**Consultation Response from KC,
 Trees**
2020/93308 Former Spotted Cow Pub, New Hey Road, Huddersfield, HD3 4BU
Erection of an A1 foodstore with associated parking, servicing areas and landscaping
Date Responded: 17/11/20
**Responding Officer: Nick
 Goddard**
Responding Ref: 61/92

Type D Retaining Wall
Scale 1:50

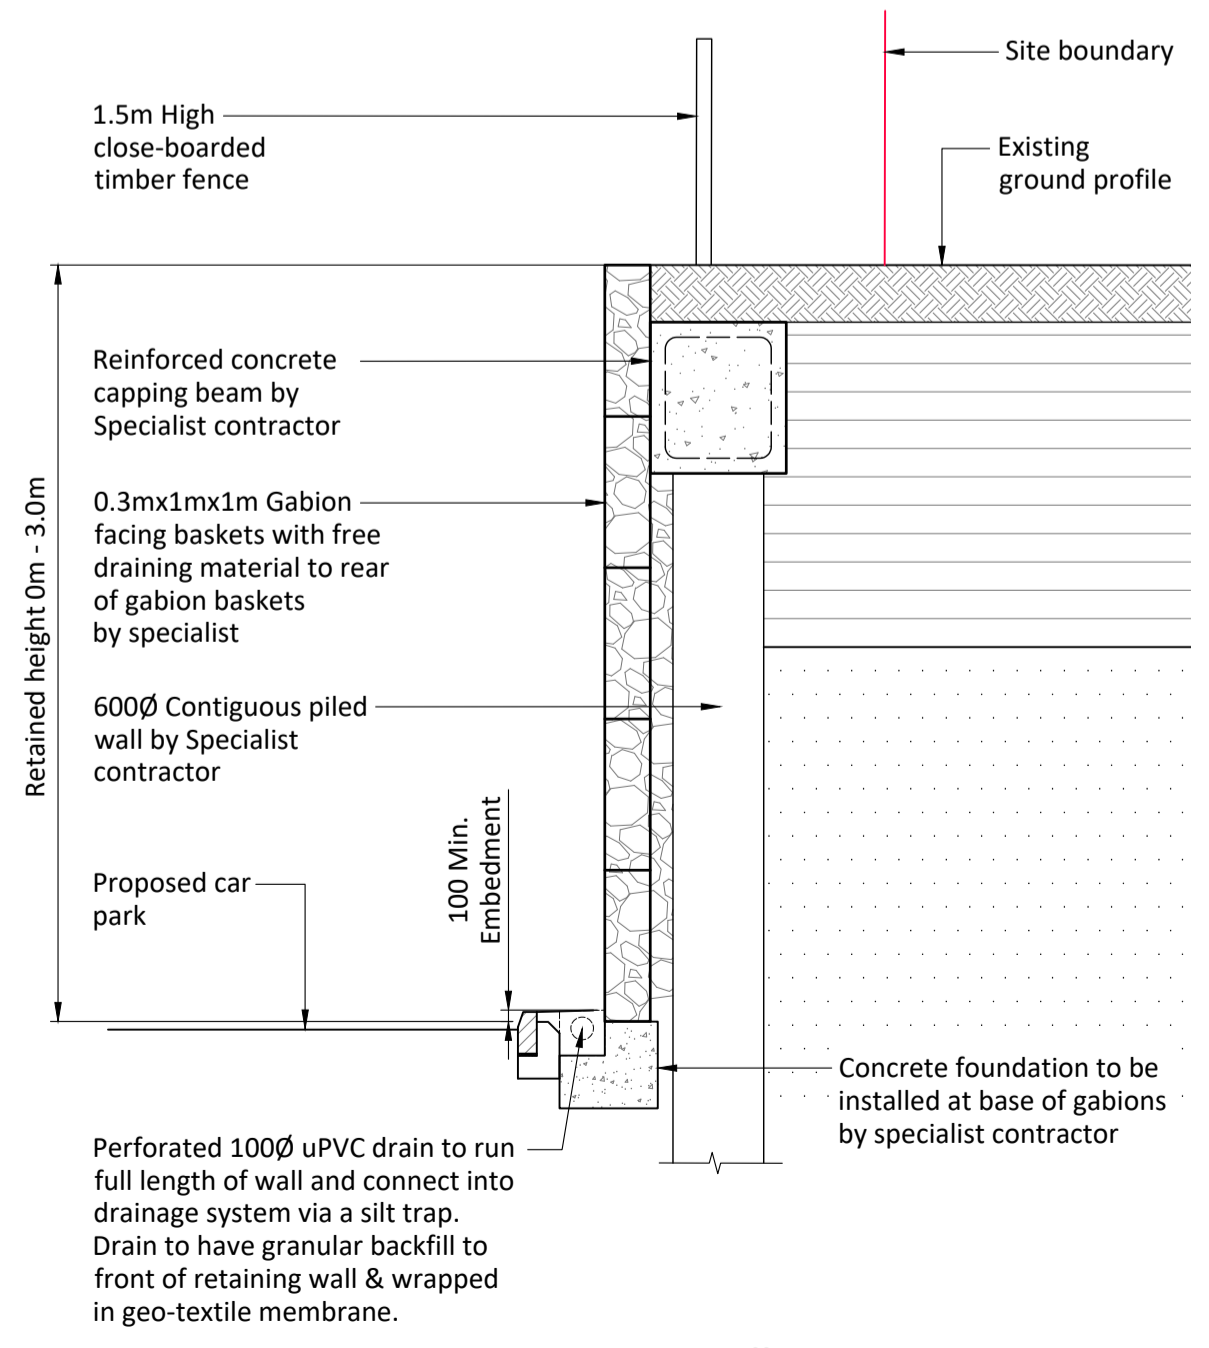
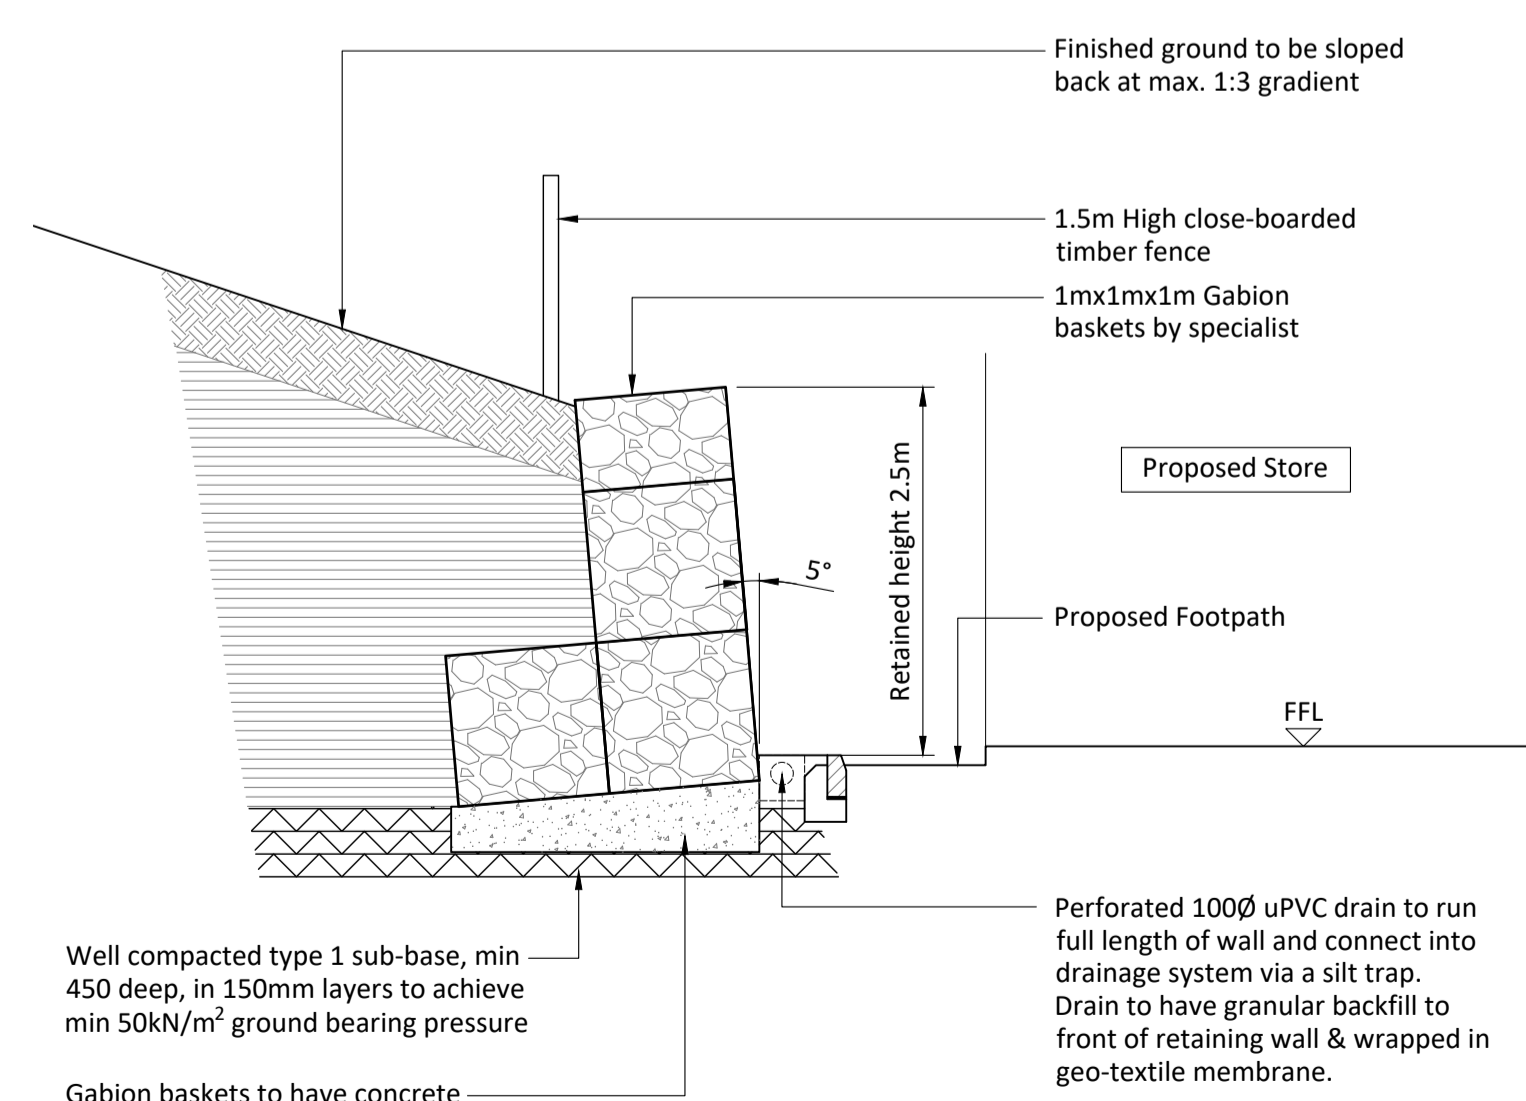
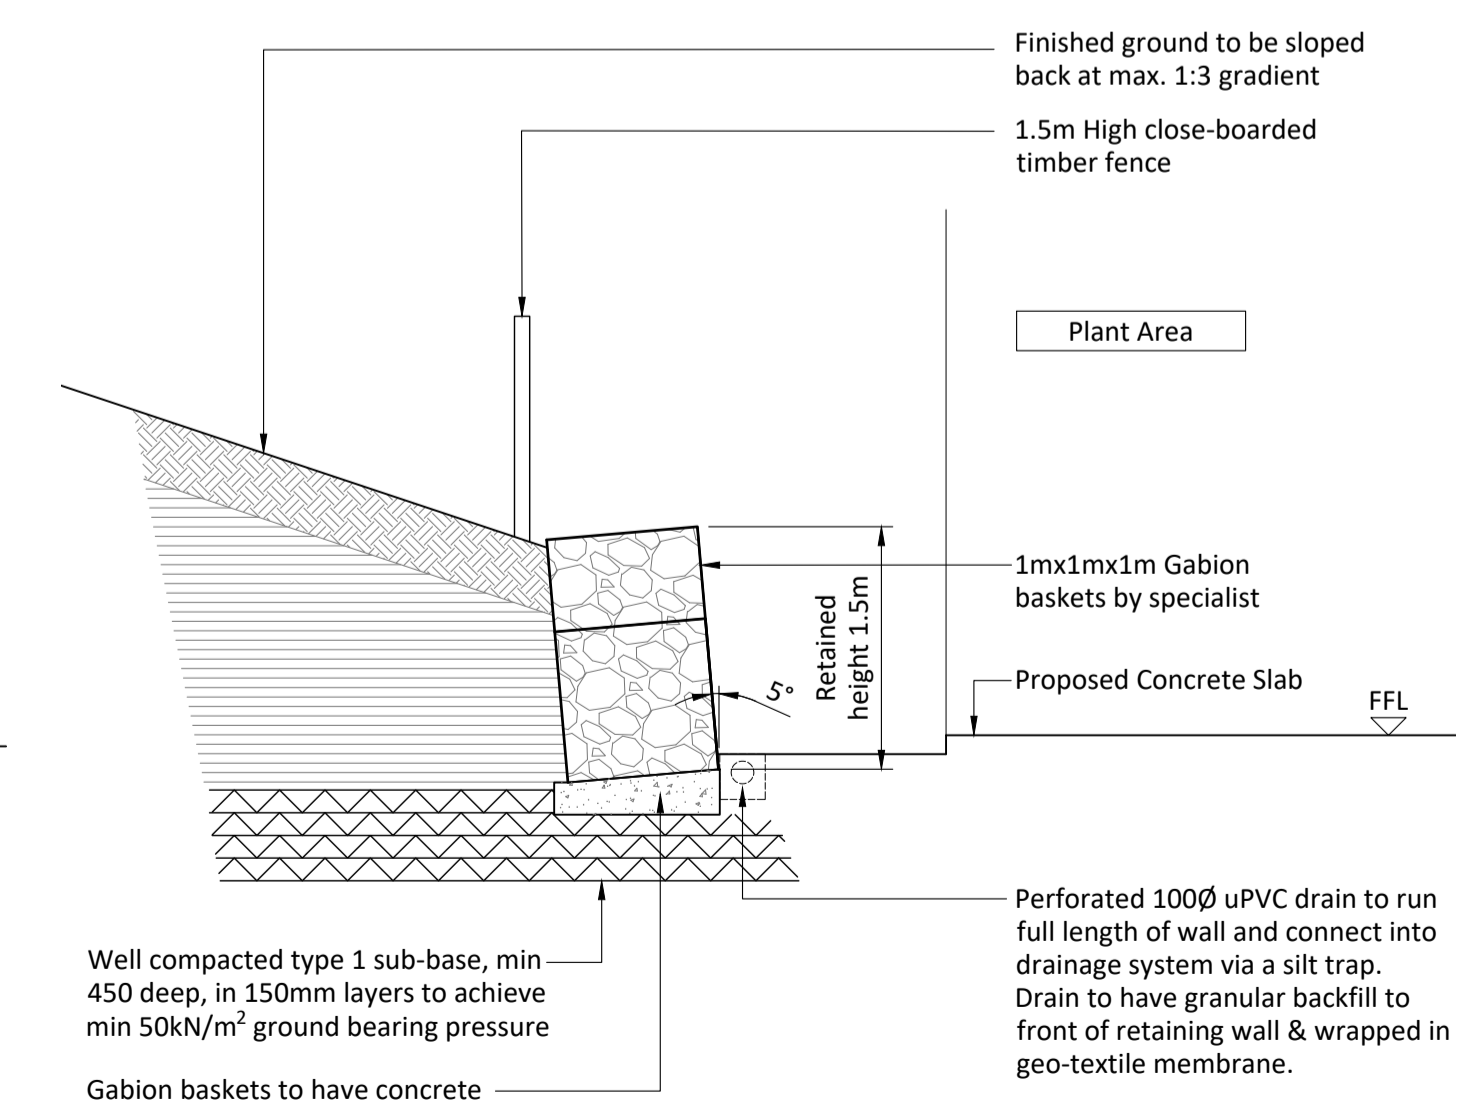
The Boundary Treatments Site Plan, shows that there is to be sheet piling and a gabion wall installed along the edge of the loading area and within the RPA of G13. The retaining wall is between 1-1.5m tall and in places is within 6m of the protected trees. There is also to be an acoustic fence installed along the site's north-western boundary which at its western end will be within the RPA of G13 and within 1m of the stem of the end tree in this group, no details of this installation within the RPA have been provided.

It is a similar question regarding the parking bay at the eastern end of the RPA of G13. To construct this required a 0.5m high retaining wall and sheet piling, all within the RPA. Given the other infringements proposed to the RPA of these trees can this parking bay not be dropped from the plans; doing so would afford much more space around the tree and give more room for the lighting column.

Appendix 7: Arboricultural Implications Plan

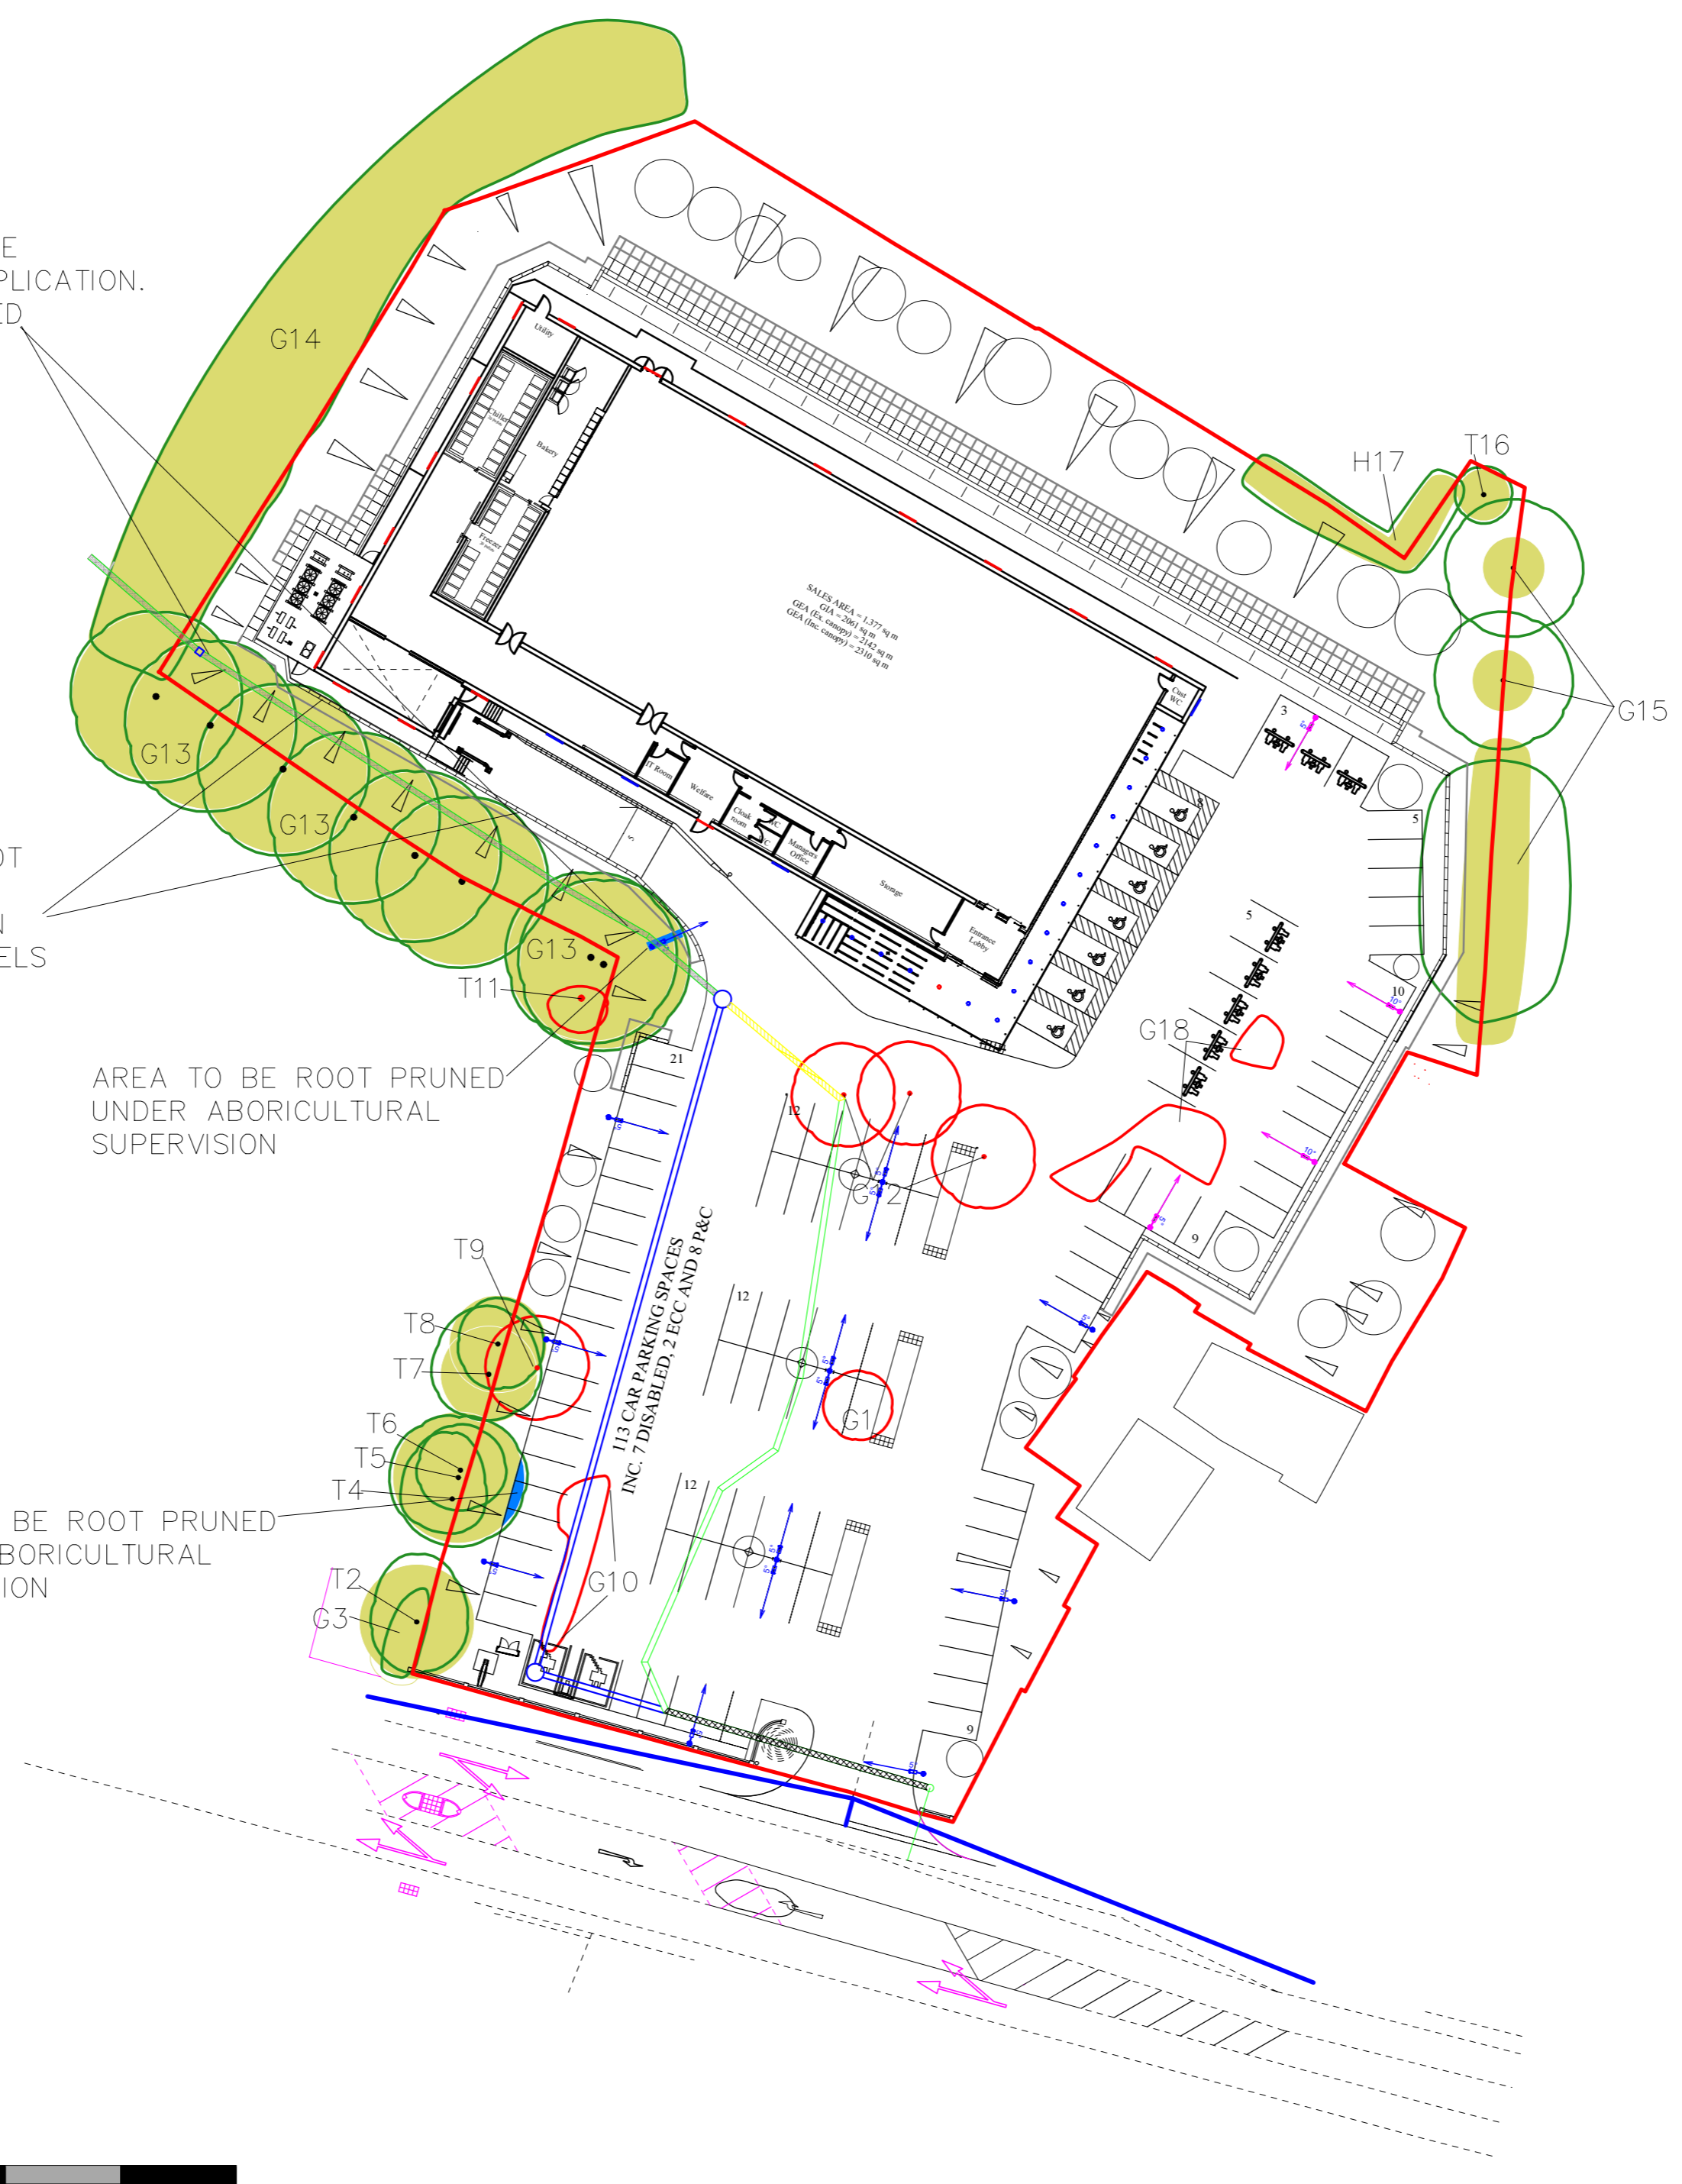
The Arboricultural Impact Assessment states there is to be no incursion of the built element within the RPA of trees. The Arboricultural Implications Plan however shows clearly there will be for trees T5 and G13. The root protection area (RPA) for G13 should extend at least 7.3m from the stem of the trees according to the data in the tree survey. The plan in the JCA report shows the developed part of the site within 5.1m of the trees in places. There is no information to suggest why this is or what impact this may have on the RPA or how the trees will be protected, either in the AIA or the AMS

Also concerning is the grading of an otherwise flat area of land within the RPA of G13, depicted on pretty much all the plans. This would have a significant impact upon the health of the trees along this boundary. The land between the retaining wall and the boundary of the site should remain untouched in terms of levels and this should be very clear on all plans.
